From: [REDACTED]
Sent: [REDACTED]
To: Iqraa Malik
Subject: RE: Request for further information AL/116/21/HH
Attachments: We sent you safe versions of your files; martin a 21 dwg 3b.pdf

site plan

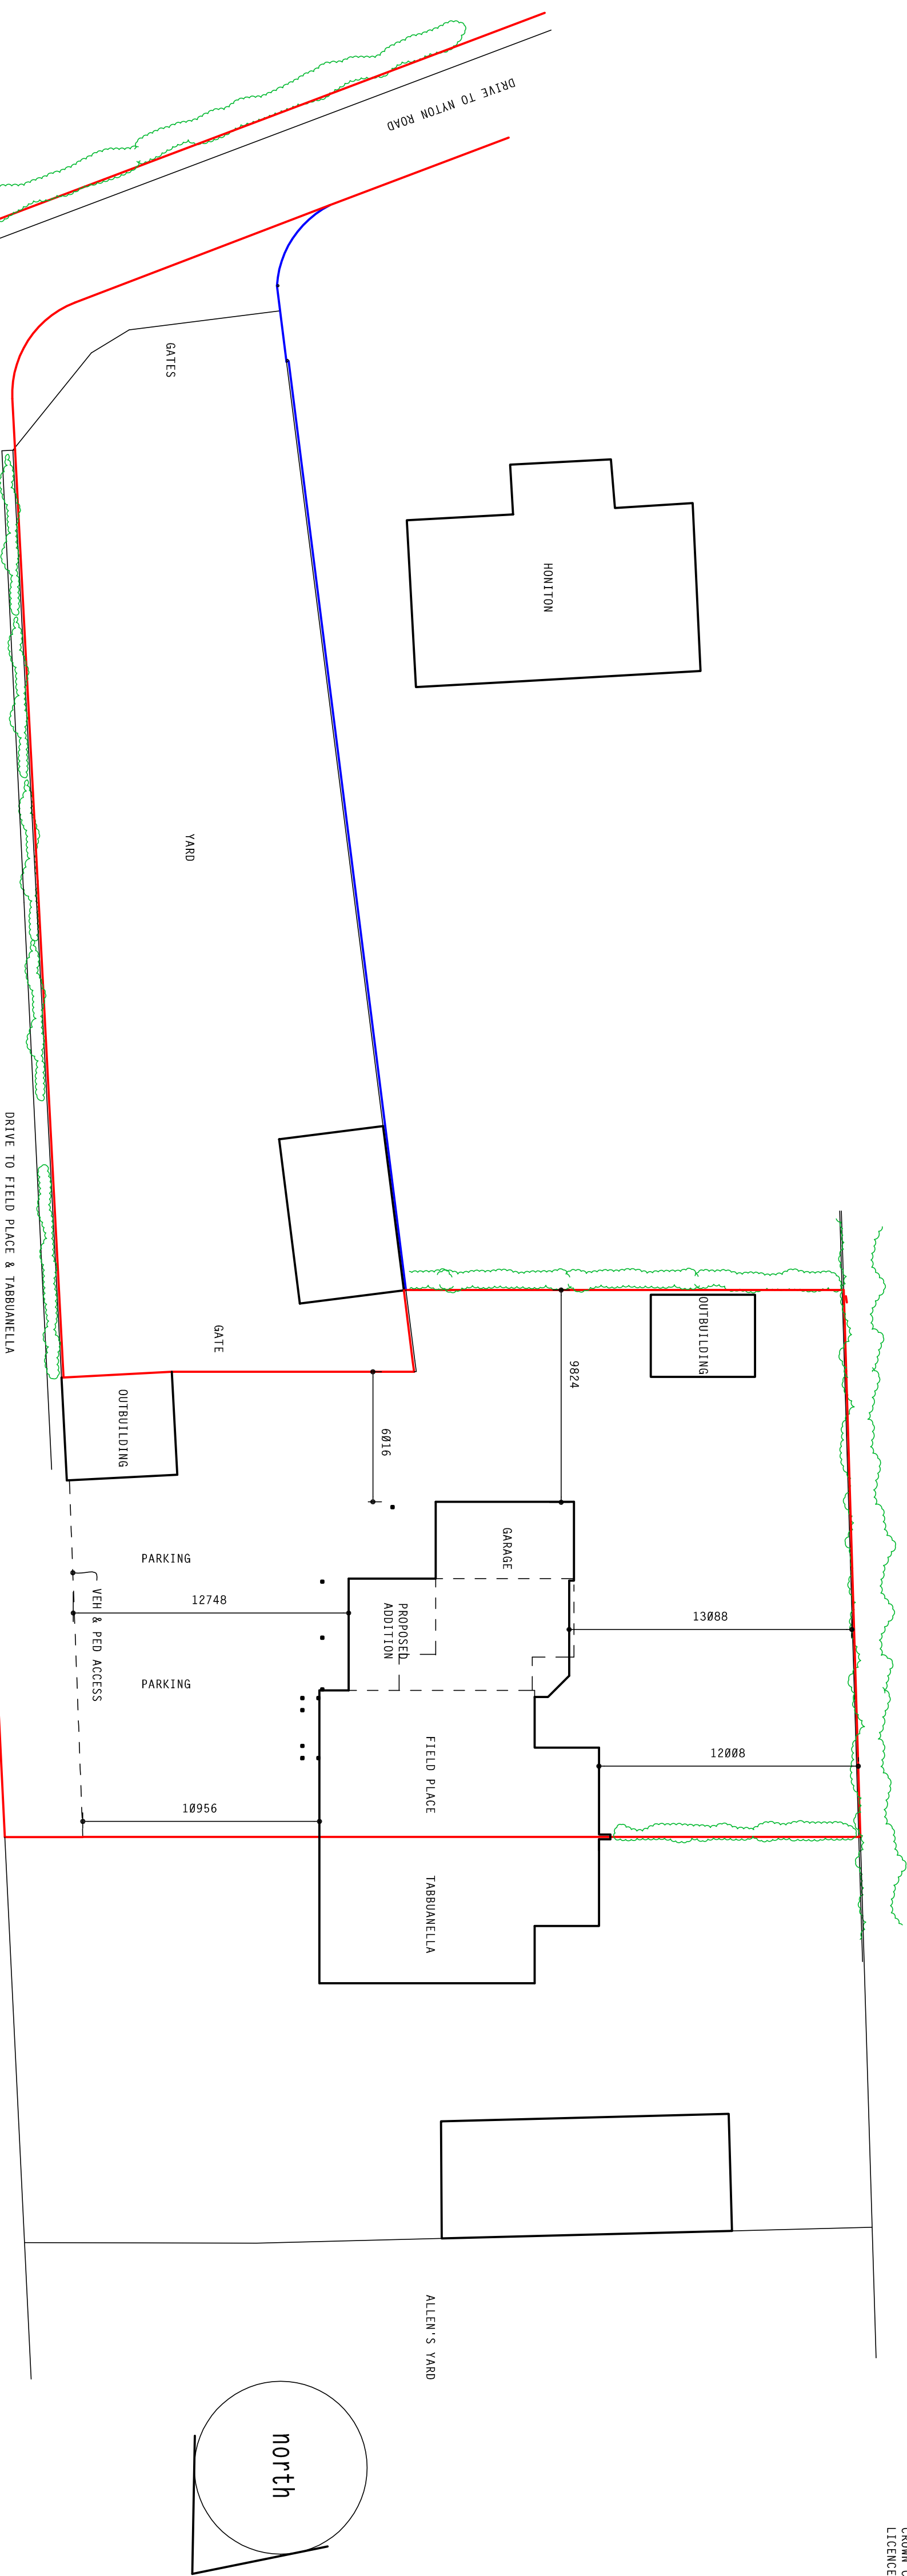
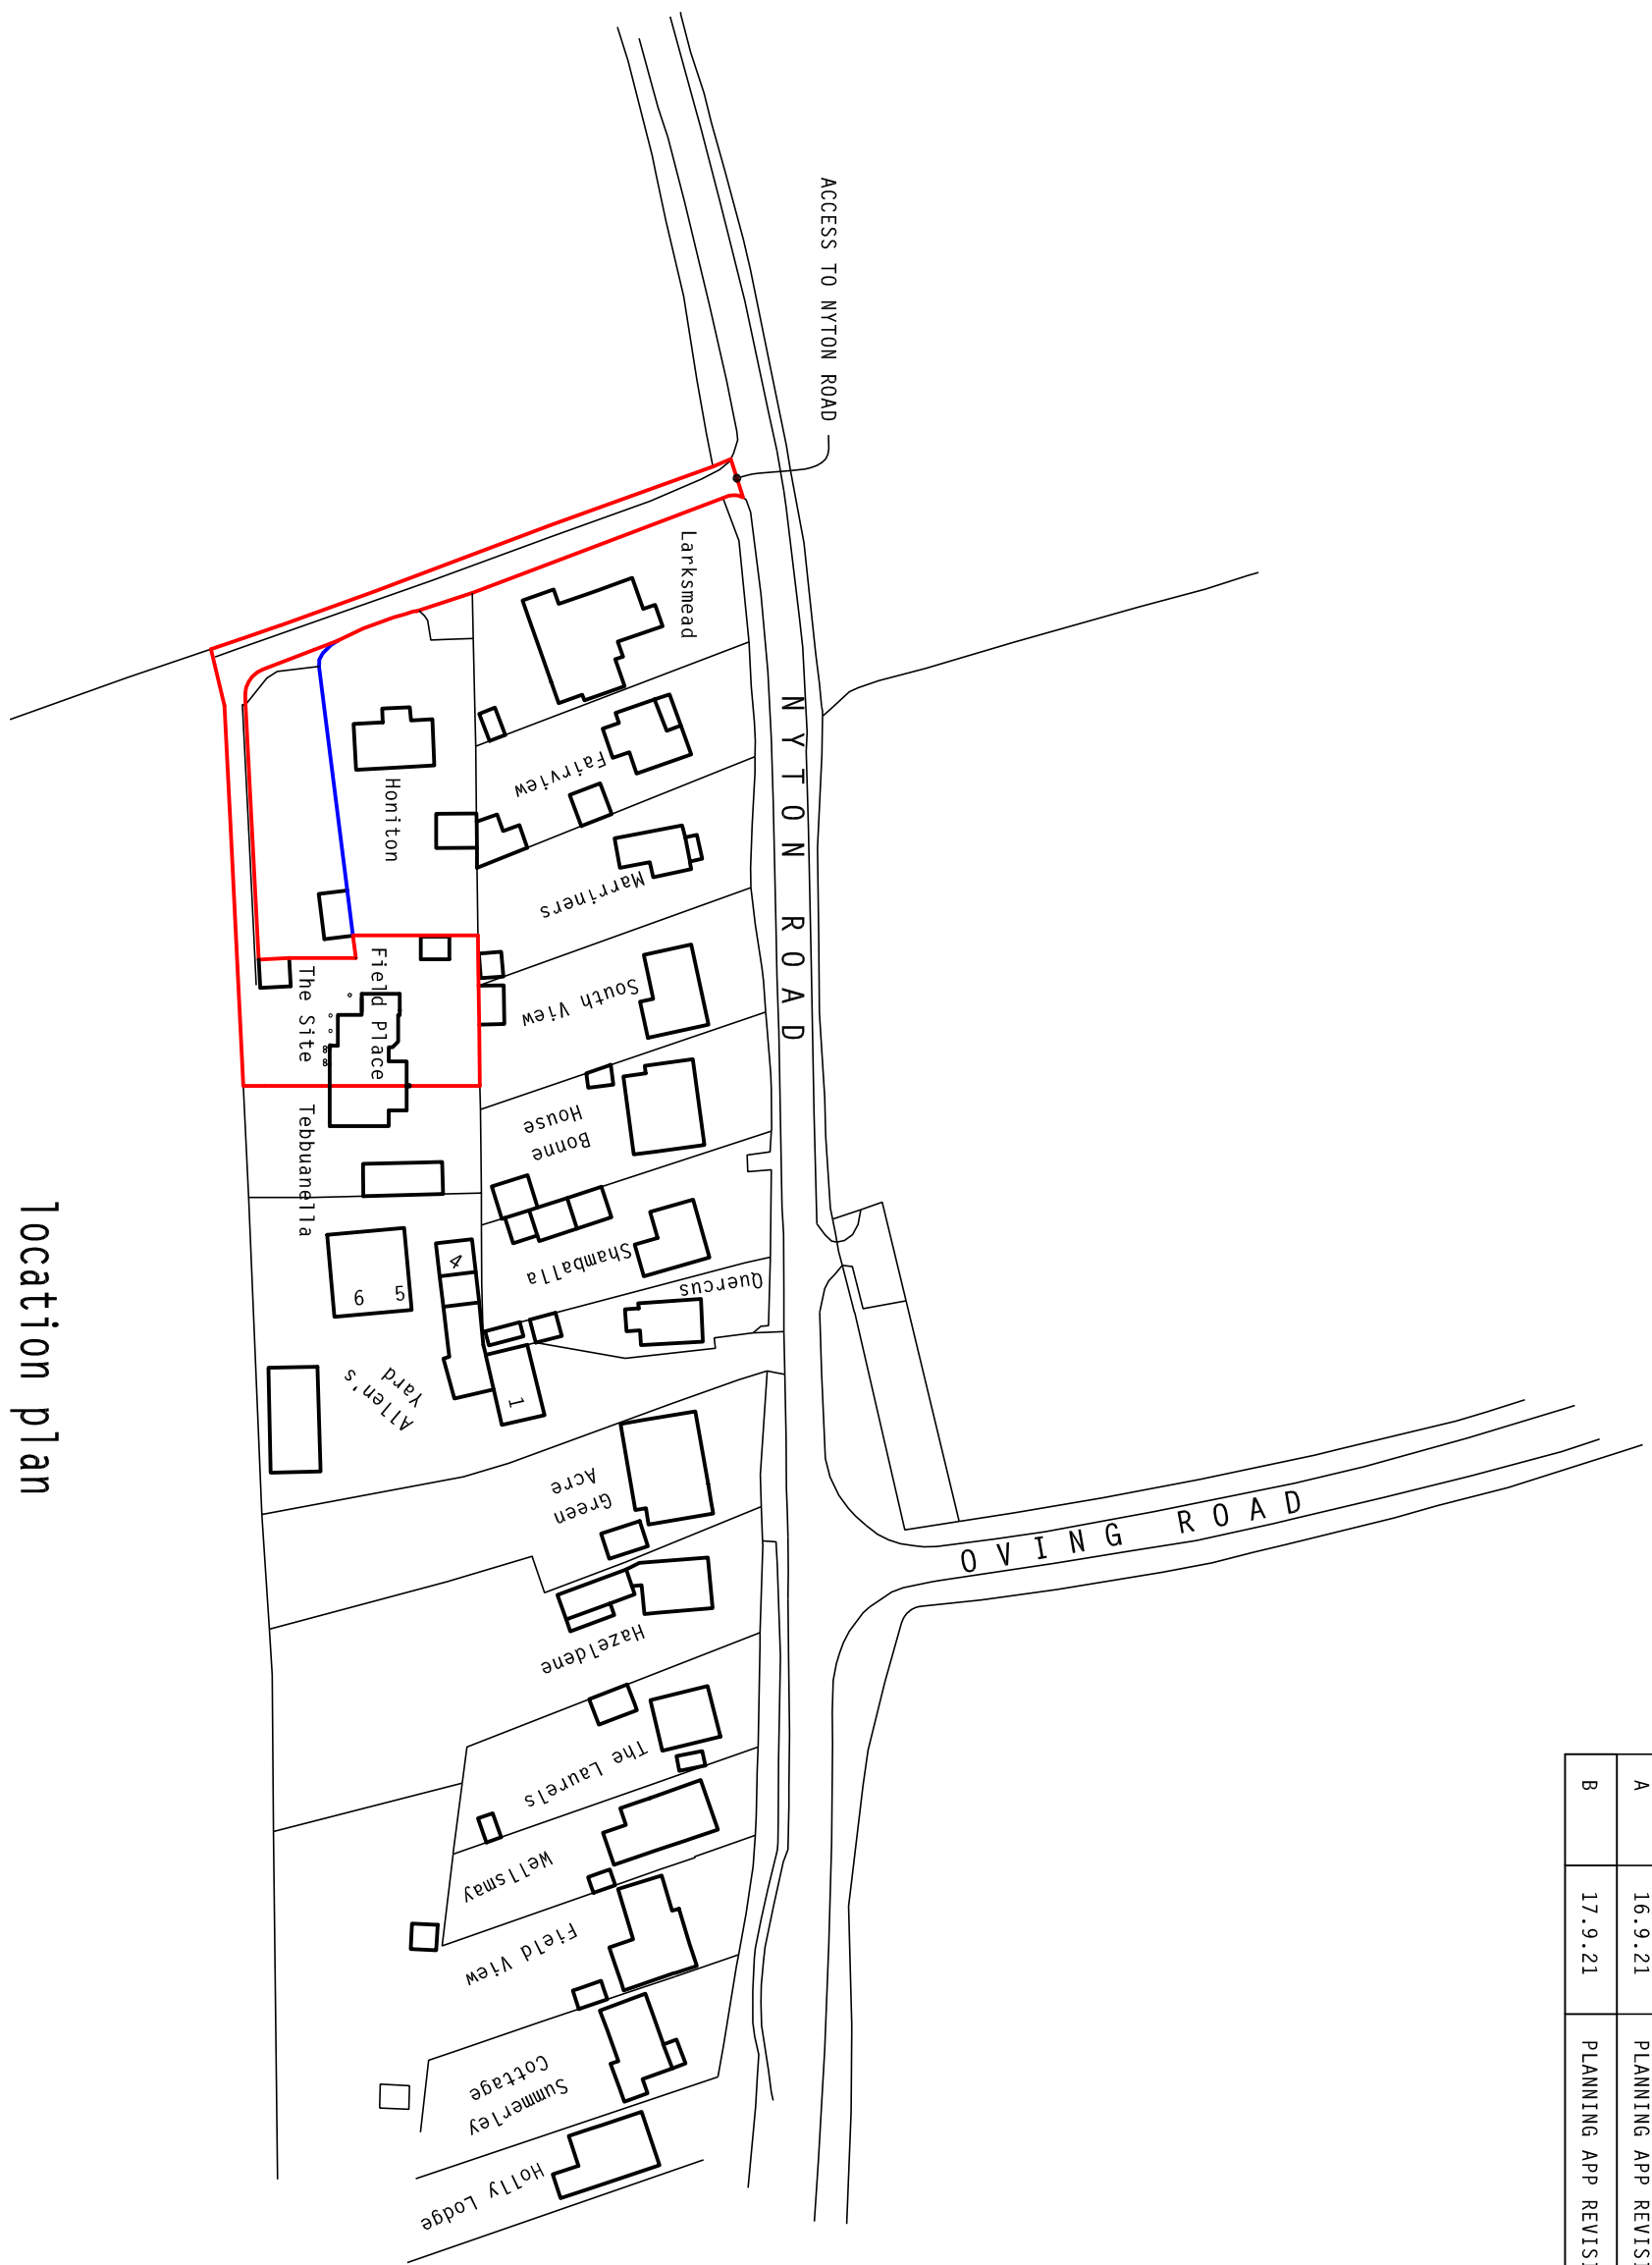
However, this application is still invalid as the red outline must be one solid outline. Along with this, you don't need to include the yard in the outline. Please amend.

Please find attached drawing 3b as requested. Adjoining yard also owned by applicants edged in blue.

Please find attached corrected CIL form as requested together with the site & location plans vehicle access outlined in red as requested. The previous site & location plans indicated the adjacent yard also owned by the applicants together and other land subject to a vehicular & pedestrian right of way etc. Please advise if the relevant notice should be served on other parties.
